Response to Planning Application

From: Arun District Council Greenspace

Application ref: CM/10/21/PL

Description: Construction of structural support for flood gates including gate housing to protect gate runners, drainage grills and planted bunding to protect against flooding (retrospective). This site is in CIL Zone 5 (Zero Rated) as other development & may affect the setting of a listed building.

Materials

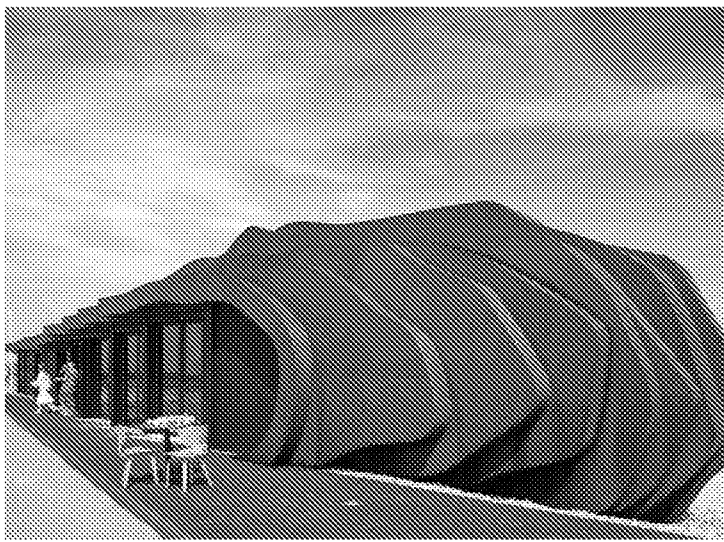
The information provided in Dwg Floodwater gate and containers does not contain sufficient information and is not clear.

- It is not clear where the white poplar whips are to be planted, whilst these would survive in this environment a shrubby mix may be more appropriate if to embankments.

- It is not shown the quantity of poplar being proposed. This information needs to clearly be shown in plan form with actual quantities, planting densities and size at time of planting.

- Grass species mix proposed for the earth bunds would be suitable for location however grasses whilst greening would not provide any screening.
- 30no English ivy in 3lt pots @ 2m spacings onto A252 8m mesh fencing will have little or no impact (for a considerable timeframe) re screening/greening and therefore would not be suitable in size or density.

- The dwg appears to suggest planting to the roof on the container? This needs to be clarified and a cross section provided which would show in section how this area would in fact be formed. ie bund height to container height and location of planting to this?

Recommend that actual quantities be provided (in plan form) and cross section provided of the proposed planting and screening proposals for this location.
